Norfolk Vanguard Project EN010079 ref. 20012468
Norfolk Boreas Project EN010087 ref. 20022983

I would like to take this opportunity to highlight the necessity of an independent design review of the combined Vanguard and Boreas substation projects.

Title:  
Viewpoint 3:  
Lodge Lane North

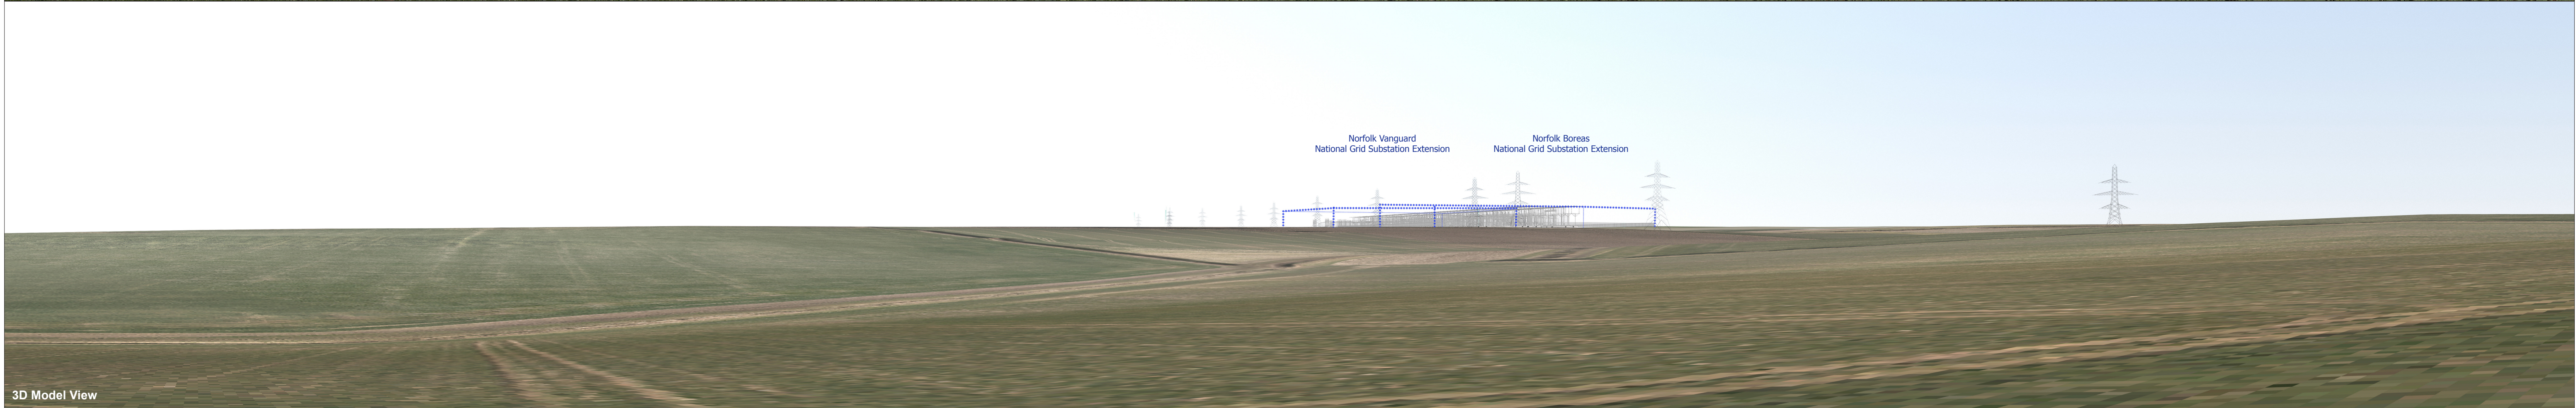
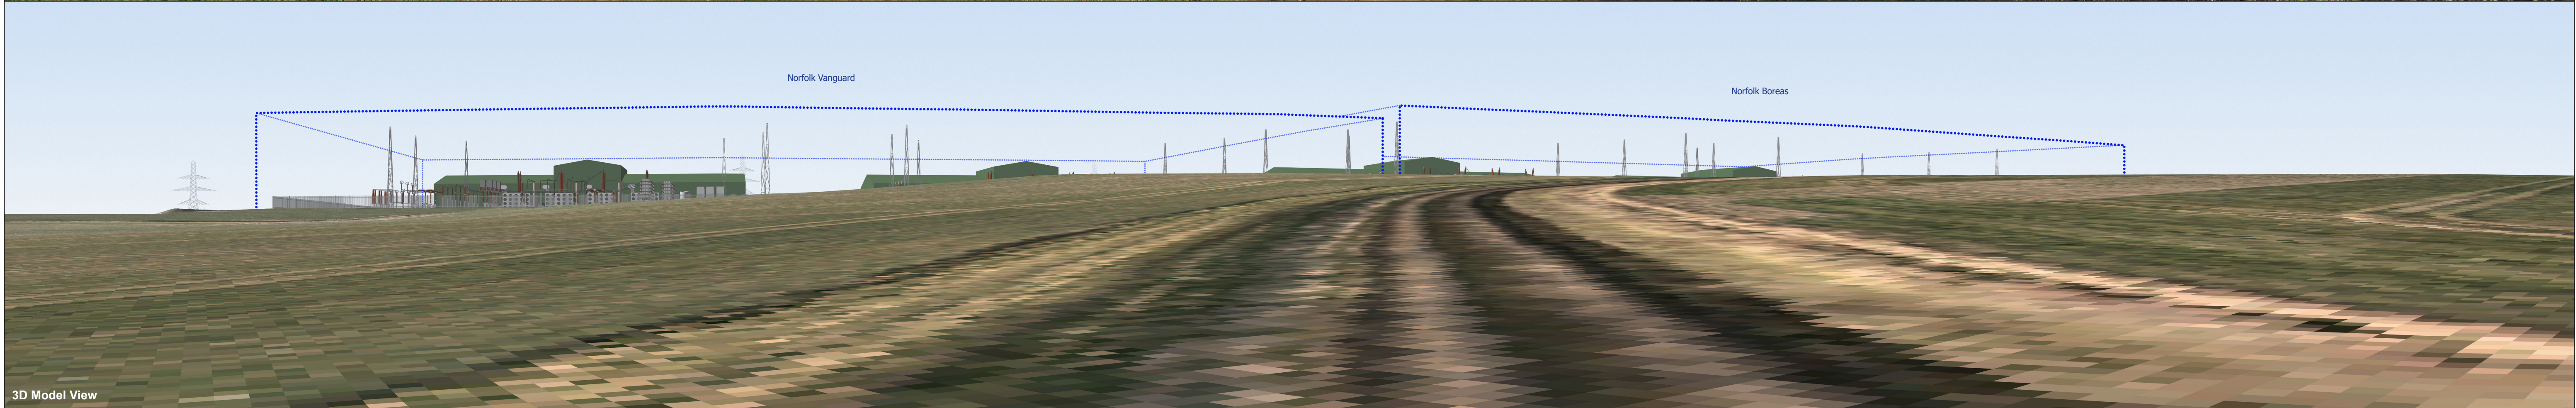
I am sure the visualisations of viewpoints 3 and 7 are not representative. Virtually all my submissions through the Boreas examination show the inaccuracy. The applicant maintains they have been prepared to a known industry standard.

This admits the visualisations are a representation of a probable underestimation of the scale of the converter buildings and a blue dotted box represents how large they could possibly be. This is not clearly explained, and is therefore very misleading.

[6.2.29.25%20Environmental%20Statement%20Figure%2029.25%20Scenario%201%20-%20Viewpoint%203%20Lodge%20Lane%20north.pdf](https://infrastructure.planninginspectorate.gov.uk/wp-content/ipc/uploads/projects/EN010087/EN010087-000684-6.2.29.25%20Environmental%20Statement%20Figure%2029.25%20Scenario%201%20-%20Viewpoint%203%20Lodge%20Lane%20north.pdf) Demonstrates there is no explanation of the blue dotted box on the visualisation and no way of knowing that the buildings could be that big, It also shows by representing the buildings as an underestimation, but they could be as big as the blue dotted box, that this massive variance makes the visualisations pretty useless.
